DELEGATED DECISION TO DETERMINE PLANNING APPLICATIONS

Reference No:	2024/62/92631/W
Site Address:	10, Thornton Lodge Road, Thornton Lodge, Huddersfield, HD1 3JQ
Description:	Installation of replacement shopfront/fascia and external canopy/fascia with integral shutters
Recommending Officer:	Molly Storer

Officer Report

Drawing No
 PL07_Rev01

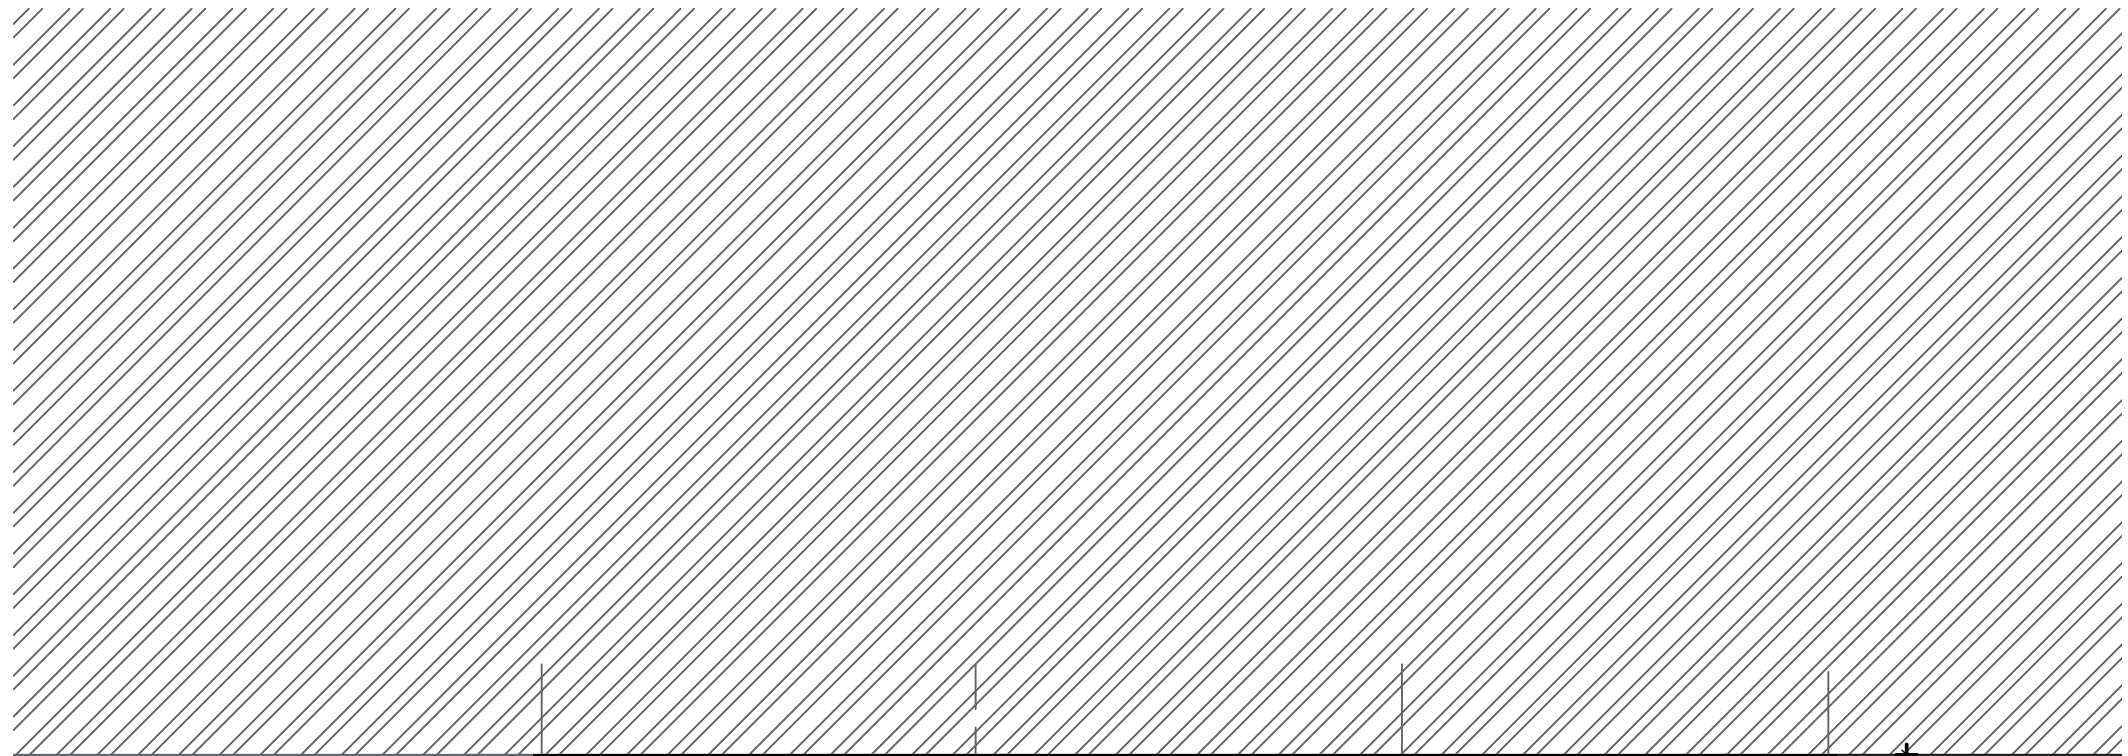
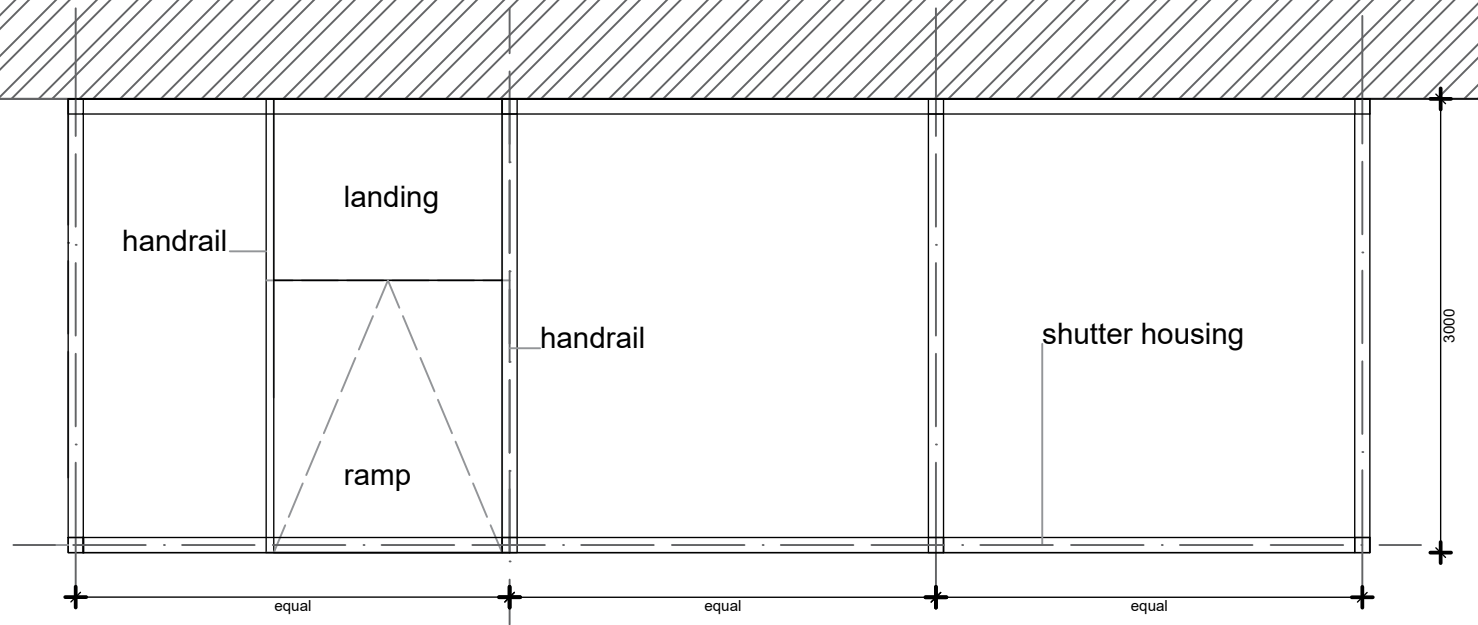
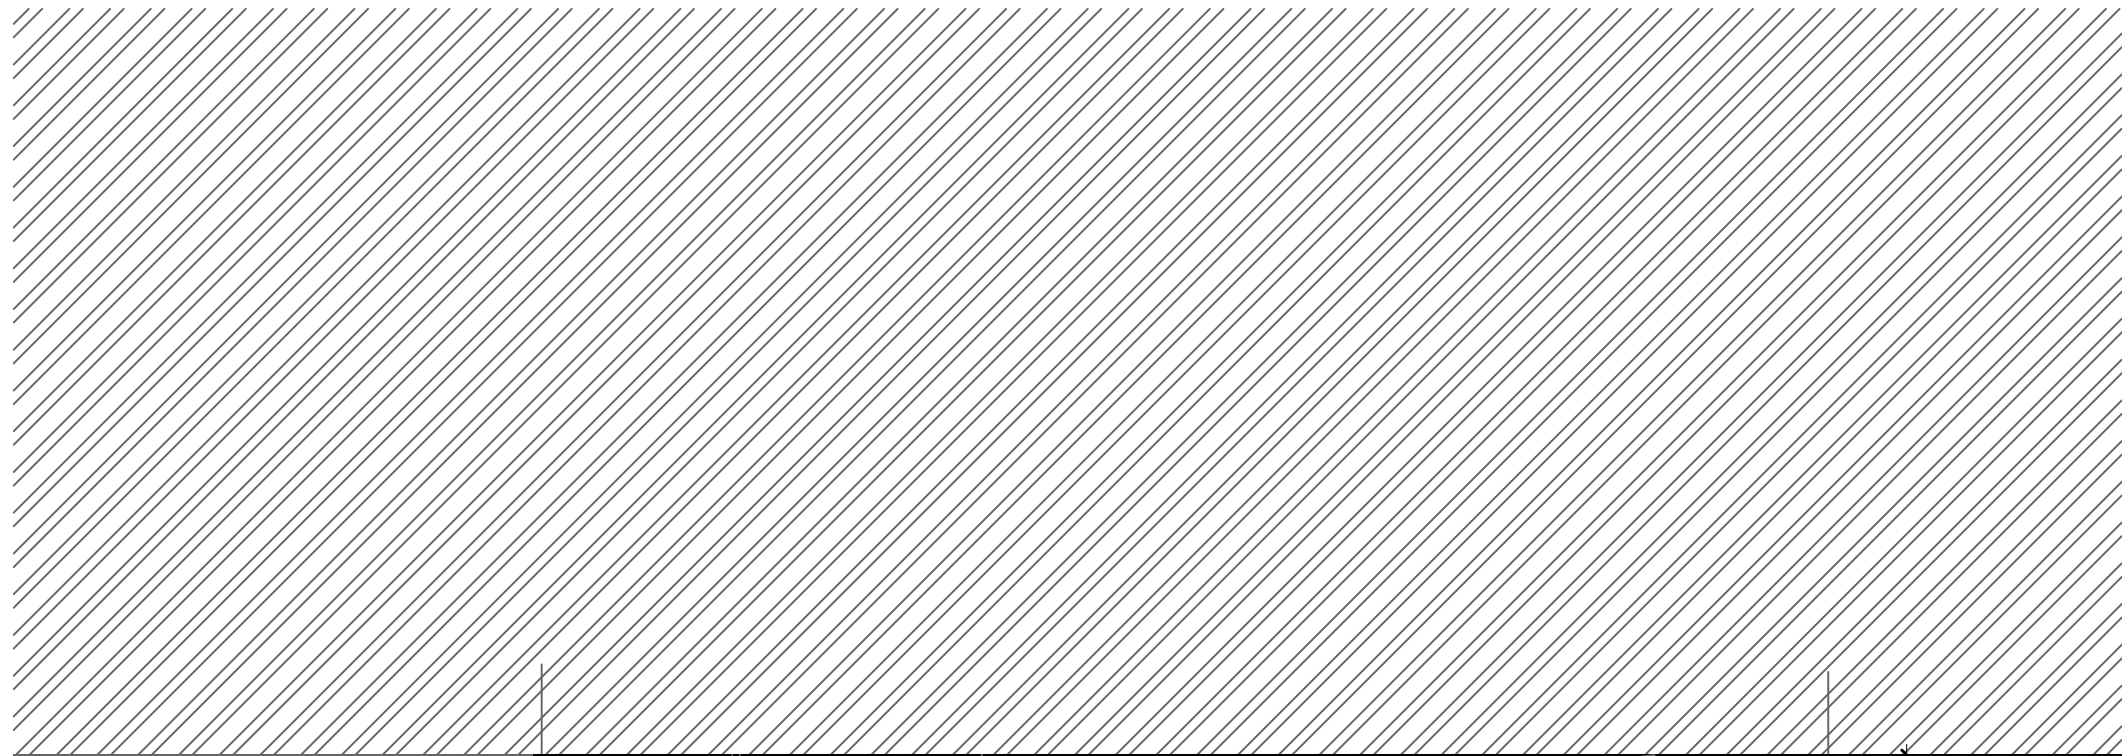
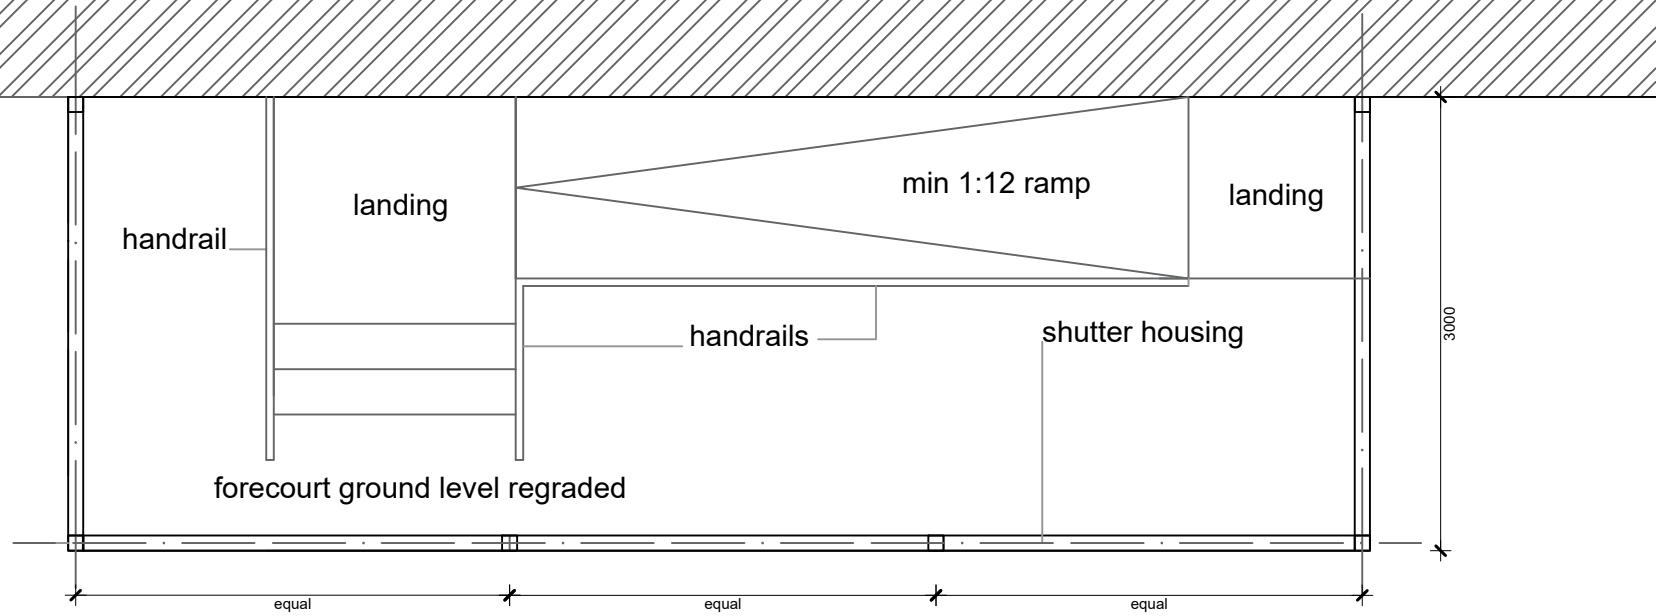
K.C. Highways: Highways comments on the original plans stated that they could not currently support the application due to the proposed access ramp not being DDA compliant and causing a pedestrian access safety concern.

Highways officers originally stated that they could not currently support the application due to the proposed access ramp not being DDA compliant and causing a pedestrian access safety concern. The agent responded with amended plans showing a DDA compliant ramp. Highways were reconsulted and stated that the revised drawings show the new ramp with a gradient of 1:12 which is the maximum acceptable ramp gradient within the DDA guidance in the Inclusive Mobility document and as such is now acceptable. This meant that concerns have been addressed and the scheme is now supportable from a highways perspective.

The agent responded with amended plans showing a DDA compliant ramp. Highways were reconsulted and stated that the revised drawings show the new ramp with a gradient of 1:12 which is the maximum acceptable ramp gradient within the DDA guidance in the Inclusive Mobility document and as

such is now acceptable. This meant that concerns have been addressed and the scheme is now supportable from a highways perspective.

Drawing No
 PL10_Rev01

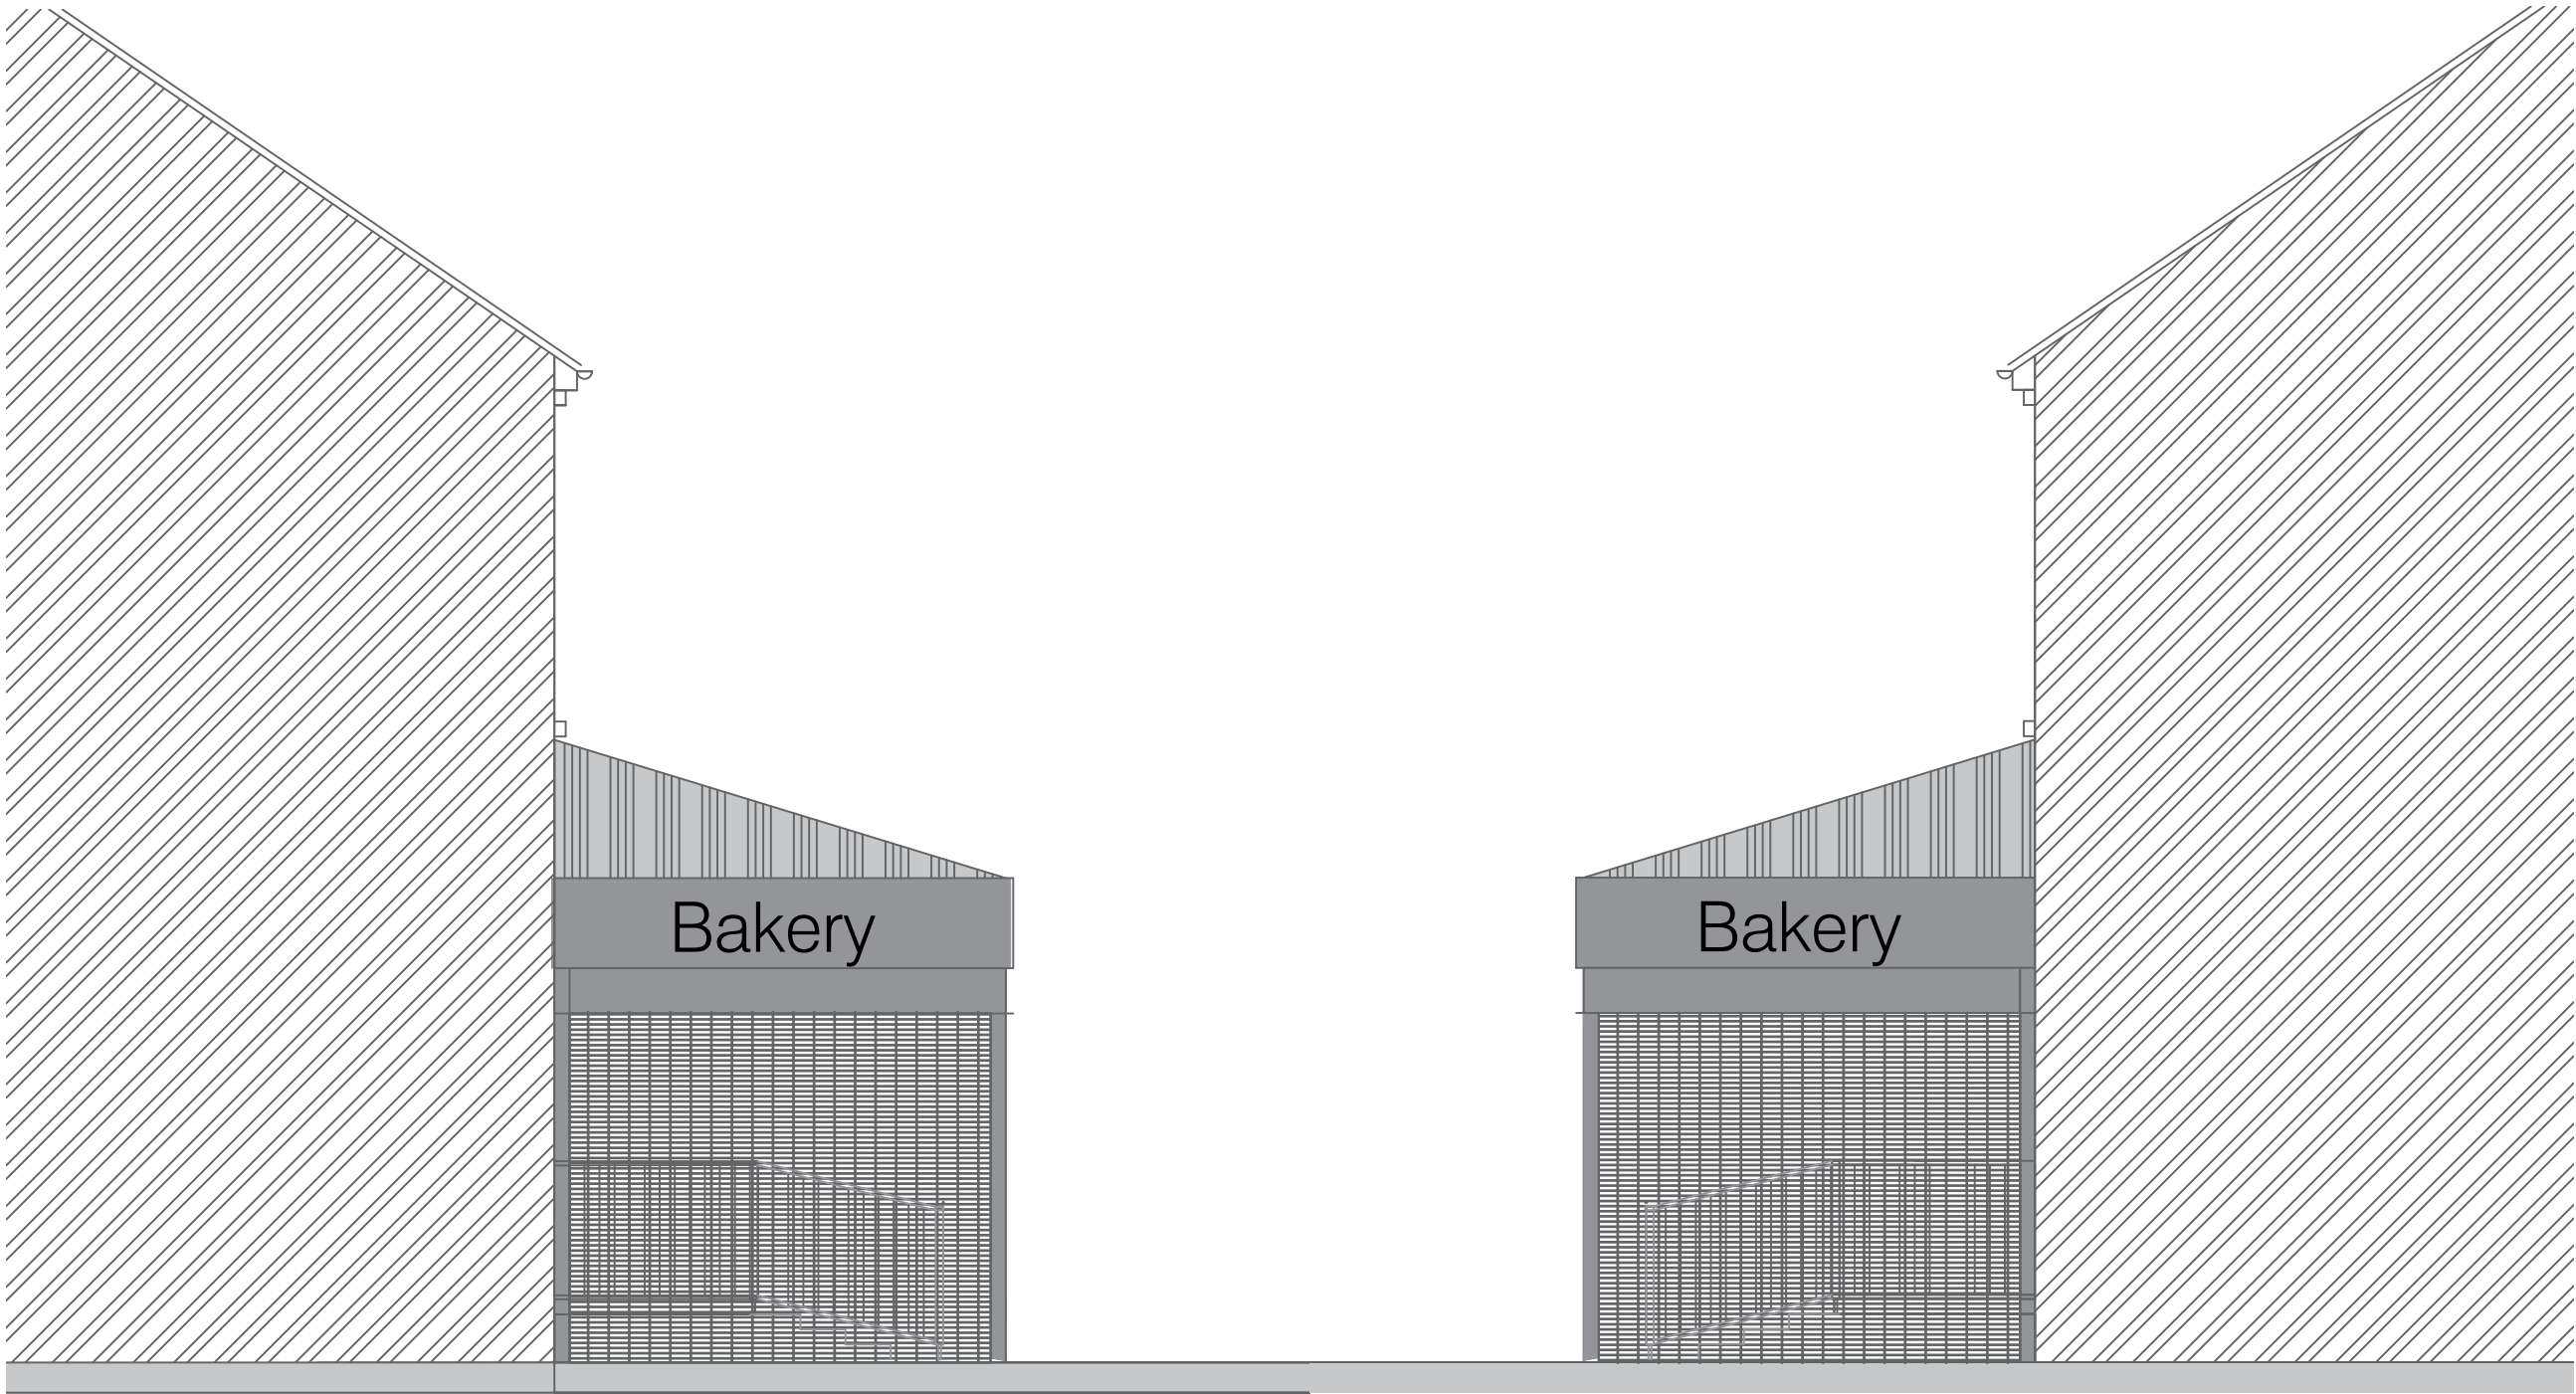
On balance, canopy and associated roller shutters are considered acceptable in this instance, with the implementation of a condition to ensure circa 60% perforation. This is because 60% perforation would prevent the visual appearance of an entirely closed shopfront when the shutters are down, whilst also reducing the risks of antisocial behaviour associated with roller shutters.

3. The roller shutters hereby approved shall be of a perforated design which provides a minimum transparency level through the roller shutters of 60% which shall be retained thereafter.
Reason: To mitigate the appearance of an inactive shopfront when the business is not in operation and to ensure the shopfront is visually appealing within the Thornton Lodge Town Centre, in accordance with policies LP2 and LP24 of the Kirklees Local Plan and policies within Chapter 12 of the NPPF.
